## Local Policing Support Team

**RE: Land rear of Paynters Croft Burndell Road Yapton BN18 0HR**

Thank you for your correspondence of the 9<sup>th</sup> of November 2021, advising me of a planning application for 23 No dwellings with associated access, infrastructure, landscape and open space (resubmission following F/5/21/PL). This application is a Departure from the Development Plan & is in CIL Zone 3 and is CIL Liable as new dwellings at the above location, for which you seek advice from a crime prevention viewpoint.

Figure 5. Features to enhance / mitigate for impacts to bats designed into the scheme.

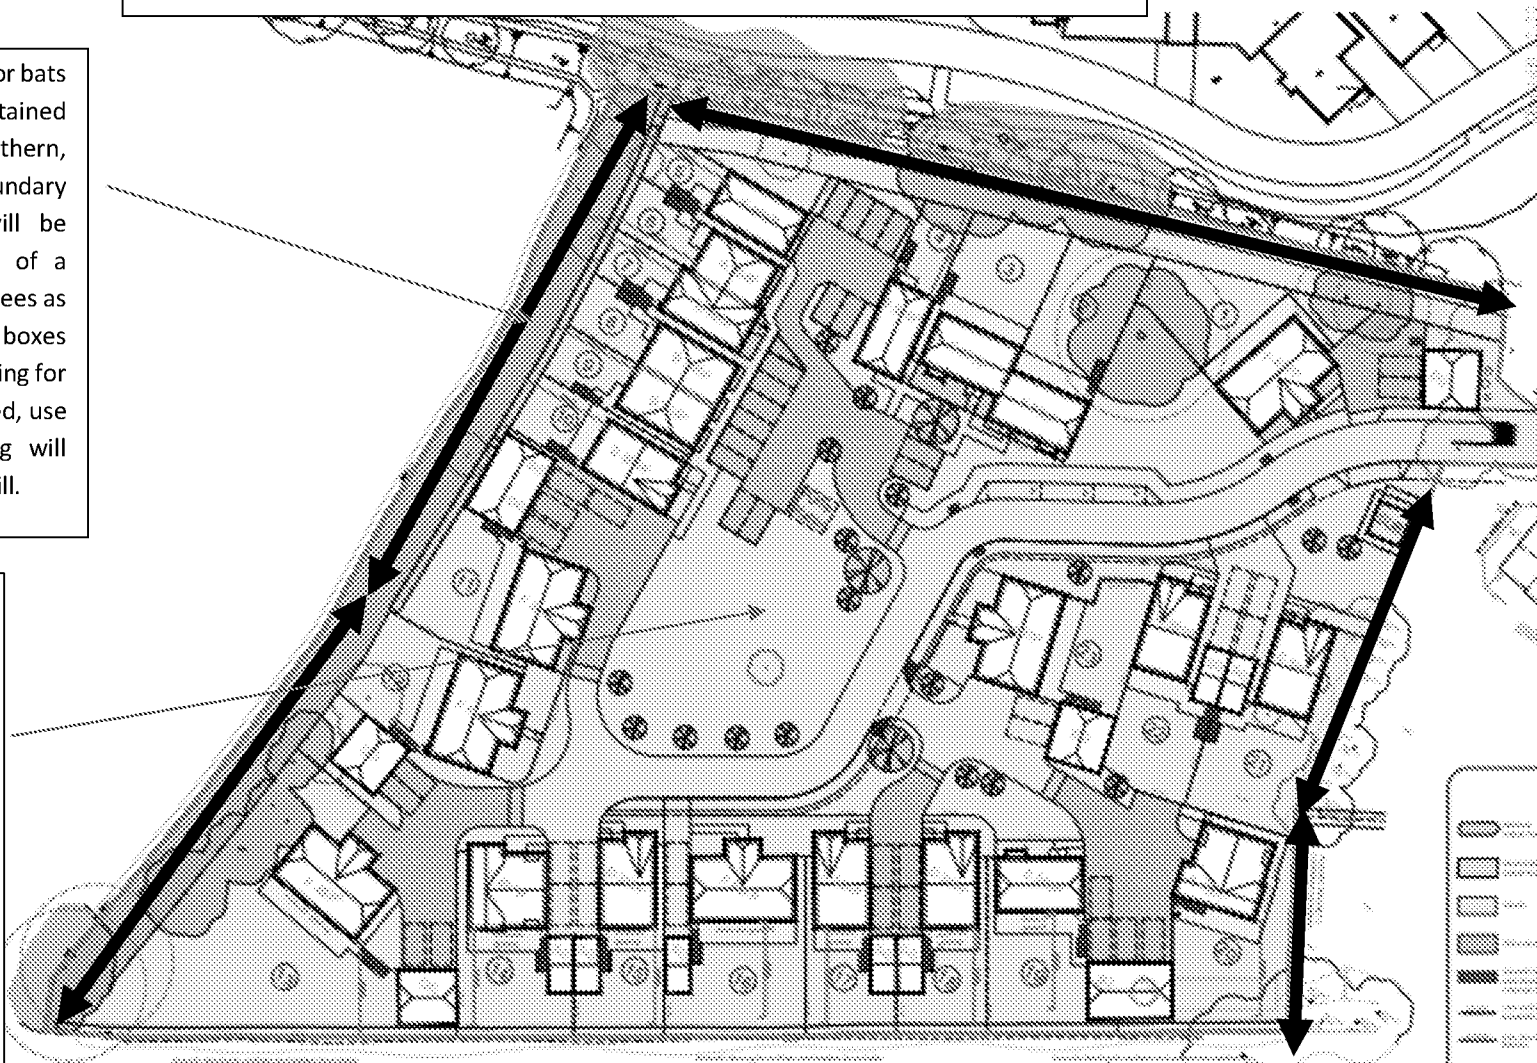
With regards to landscaping - ground planting should not be higher than 1 metre with tree canopies no lower than 2 metres. This arrangement provides a window of observation throughout the area.

Finally, lighting throughout the development will be an important consideration and where it is implemented it should conform to the recommendations within BS5489-1:2020
